From: [Cathy Pye](#)
To: [A47 Blofield to North Burlingham](#); [REDACTED]@planninginspectorate.gov.uk
Cc: [Sonya Dickinson](#); [Chris Gates](#); [Tony](#)
Subject: A47 dualling - Blofield to North Burlingham
Date: 20 July 2021 11:55:52

Re: A47 dualling, Blofield to North Burlingham.

Walkers, Cyclists and Horse Riders – Proposed overbridge at B1140

Figure 4.2: Proposed improvements to walking and cycling provision (Extract from ES Figure 12.2)

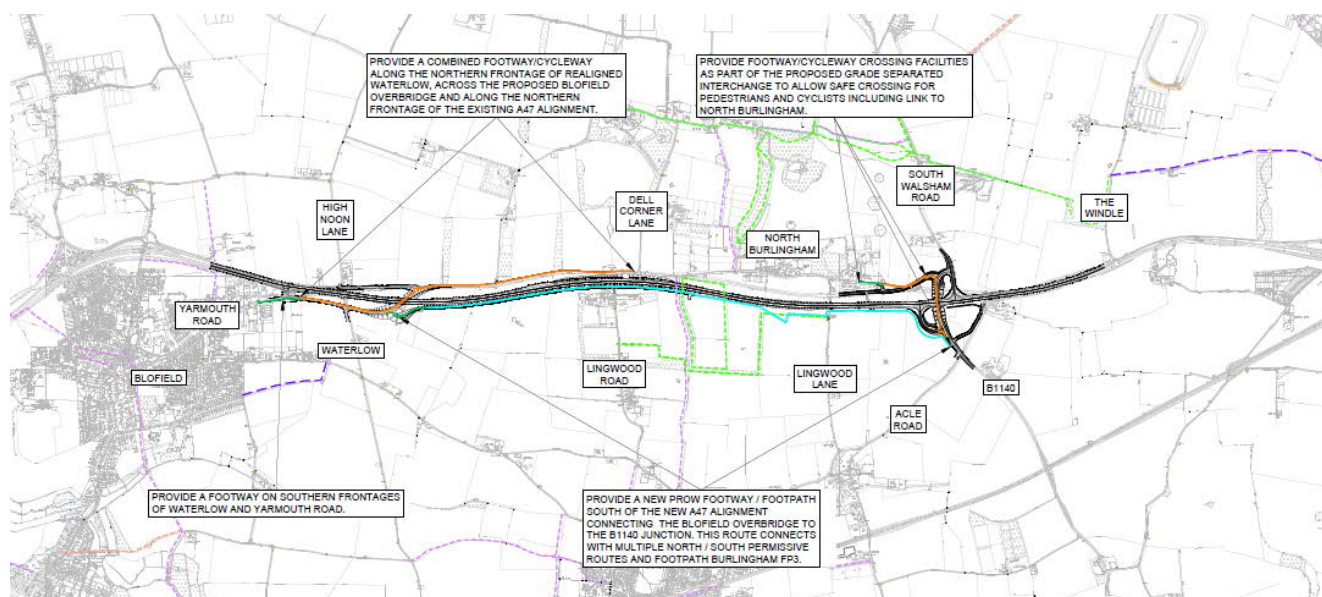
Highways England's document, 'Case for the Scheme' (The Impact of the Scheme on Walking and Cycling, 4.4.8) states, *“The Scheme provides support to walking, cycling and vulnerable users by incorporating safe, convenient, accessible and attractive routes for pedestrians and cyclists to improve connectivity in areas local to the Scheme”*.

We take issue with this assertion. As mentioned previously, the A47 divides the Parish of Lingwood and North Burlingham. The Proposed Scheme includes a footpath on the proposed overbridge at the B1140 instead of an underpass or footbridge. Highways England maintains this is adequate to replace Burlingham FP3 which will be blocked.

Residents who live north of the A47 and who wish to cycle to their designated parish facilities in Lingwood (listed in our previous remarks) will be expected to cross the busy B1140, then travel over the proposed overbridge alongside convoys of HGVs and other traffic. Once over the

bridge, cyclists will travel onwards while the HGVs will be turning left across their path.

As mentioned in our previous remarks, the distance from North Burligham to Lingwood across the overbridge would be too far for most pedestrians to walk. With no other option to cross the A47, they will be forced to drive, adding to the volume of traffic on the overbridge.

I assume no horse rider would attempt to use this overbridge!

How can the proposed overbridge be '*safe, convenient, accessible and attractive*'? And how does it improve connectivity in our parish if people are now forced to use cars?
